**Application no: 22/02780/DISC**

**Location: Bicester Heritage, Buckingham Road, Bicester**

## **Lead Local Flood Authority**

**Date: 07/11/2022**

Tel: 01865 240071  
Fax: 01865 248006  
e-mail: oxford@aksward.com  
web: www.aksward.com

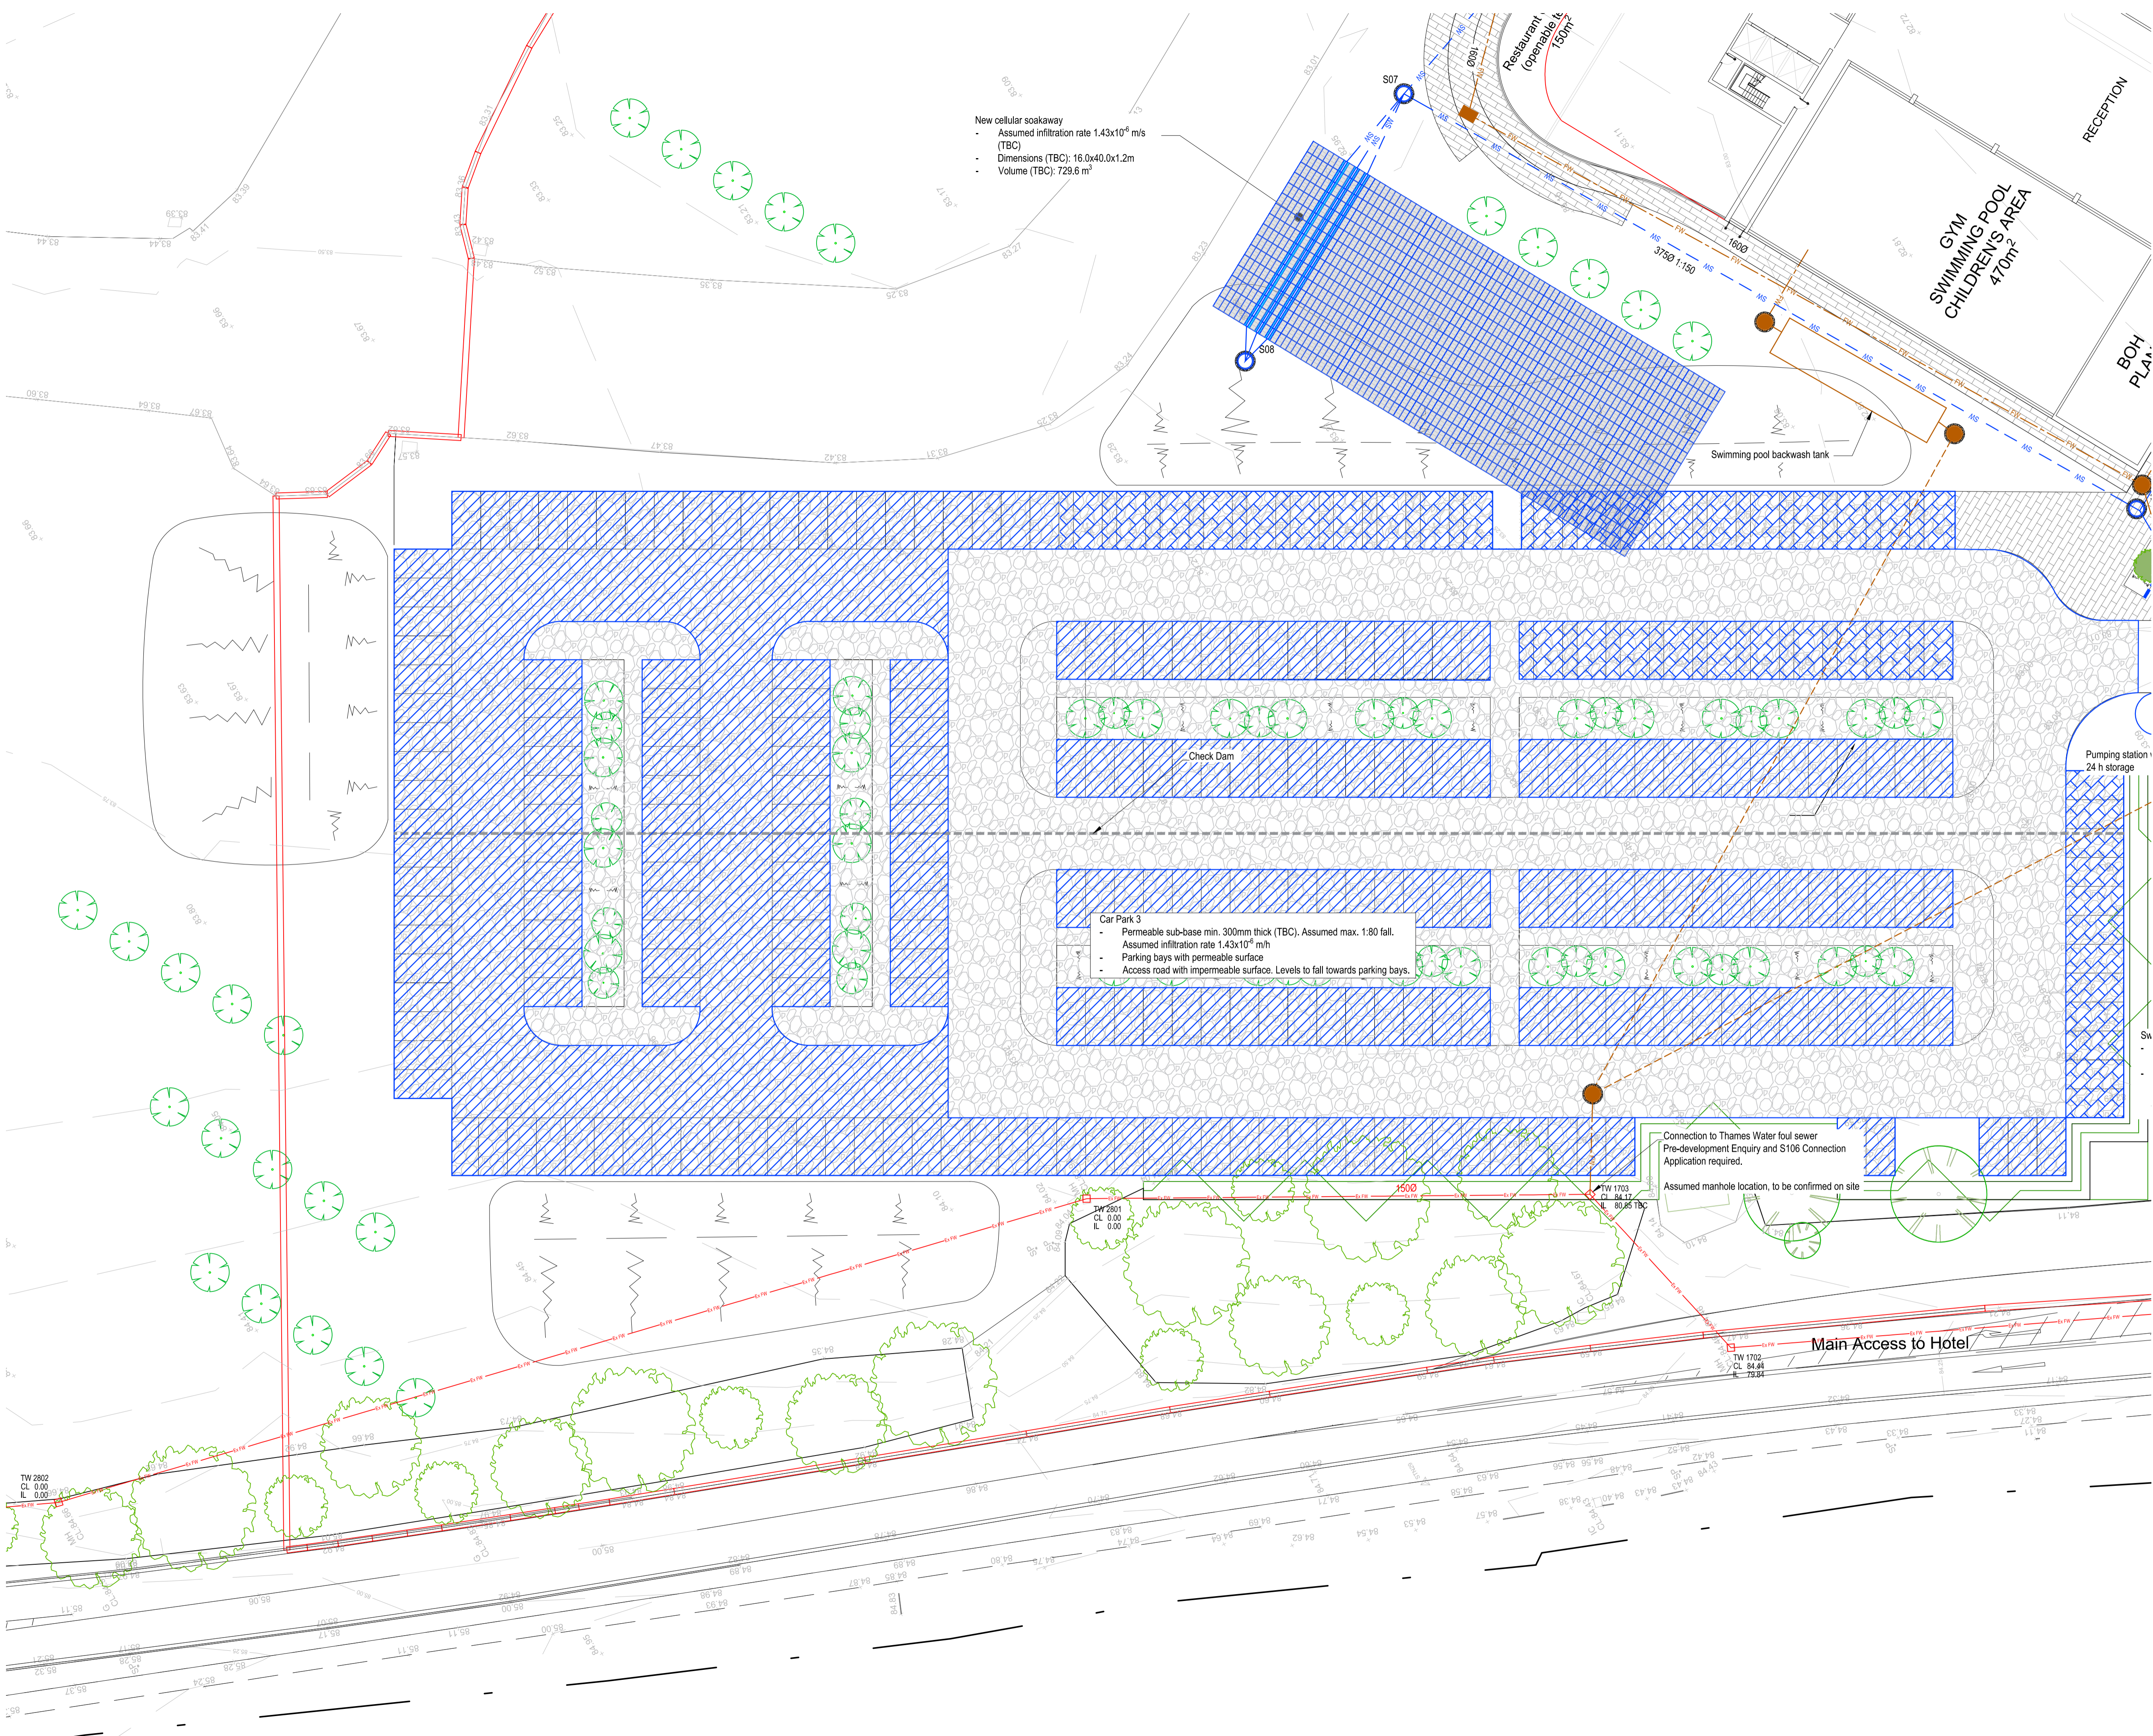
Provide discharge rates on the drainage plan for each proposed SuDS.

Provide surface water catchment plan which clearly indicates the extent of the impermeable areas and to which SuDS feature it will drain to. Currently some areas has been given but its unclear to which SuDS feature it will drain to.

Clarify the Key on the drainage plan, is the hard standing areas in grey permeable paving or will this drain towards the permeable paving in blue.

The drainage plan is not detailed, show the RWP pipes and how its connected to the SuDS.
